From: Clear, Gwen (ECY) <GCLE461@ECY.WA.GOV> on behalf of ECY RE CRO ERTS COORDINATOR <CROERTS@ECY.WA.GOV>
Sent: Wednesday, December 24, 2014 9:51 AM
To: Kaycee Hathaway
Subject: Revised comments for CU-14-00005
Attachments: 3789 revised Gonzalez.pdf

Re: CU-14-00005

Thank you for the opportunity to comment during the optional determination of nonsignificance process for the farming operations related to KC 17.15.060.1 A – Marijuana Processing and Production on a 15.03 acres parcel, proposed by Mary Gonzalez. We have reviewed the documents and have the following revised comments.

1006 Emerson Rd.

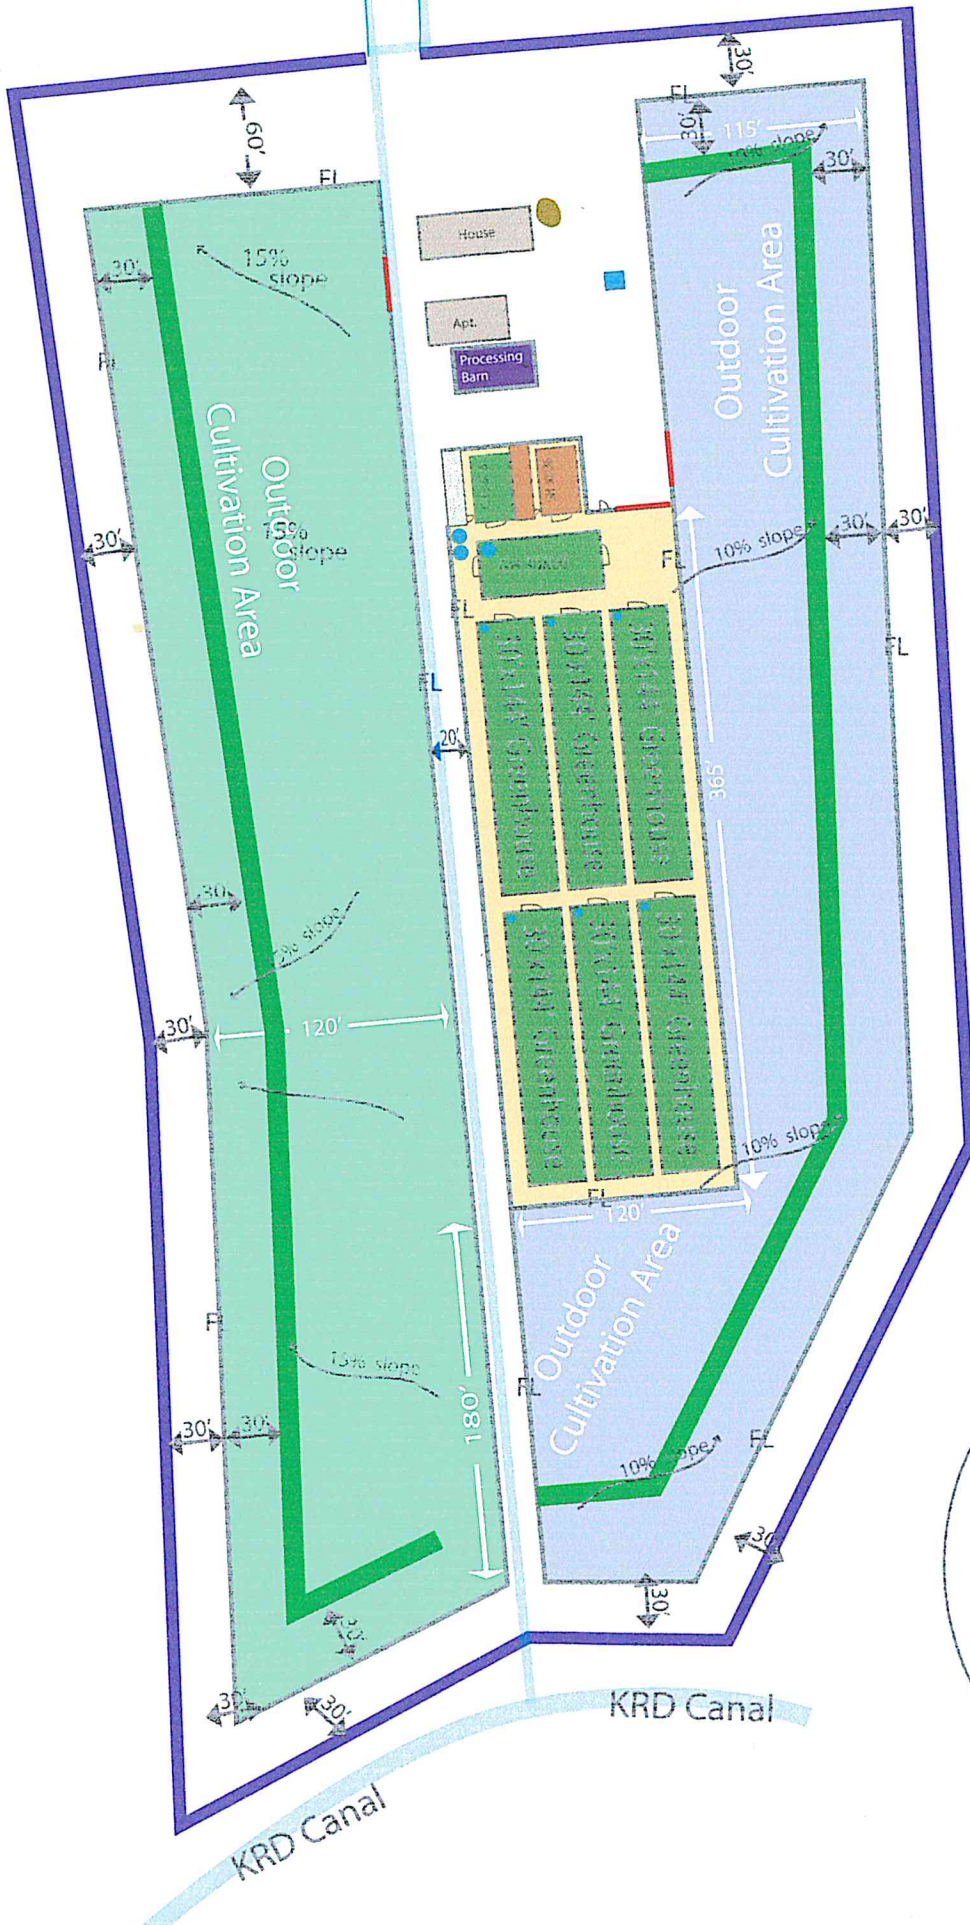
Ecology recommends that all phases of the commercial cannabis growing development be described in this environmental checklist form. A site plan was available, but very little details of the plan were included in the environmental checklist answers. No build-out information, such as total square feet of impervious surfaces or square feet per phase, was provided to this reviewing agency.

The wetlands on site should be delineated and rated to assure that appropriately sized buffers are in place throughout all phases of the project to protect the wetland functional values. In later phases of the project, the buffer from the wetlands is proposed to be cut in half to 60 feet. At this size buffer (combined with a slope) only 50 to 70 percent of nutrients being applied on the surface could expect to be treated by an intact vegetated grass buffer. The impacts of the use of fertilizers on the adjacent wetland should be evaluated. Measures that will be employed by the applicant to protect the water quality and other functional values of the wetlands on site should be described by the applicant. Periodic assessment of the impact of the project on adjacent wetlands is recommended.
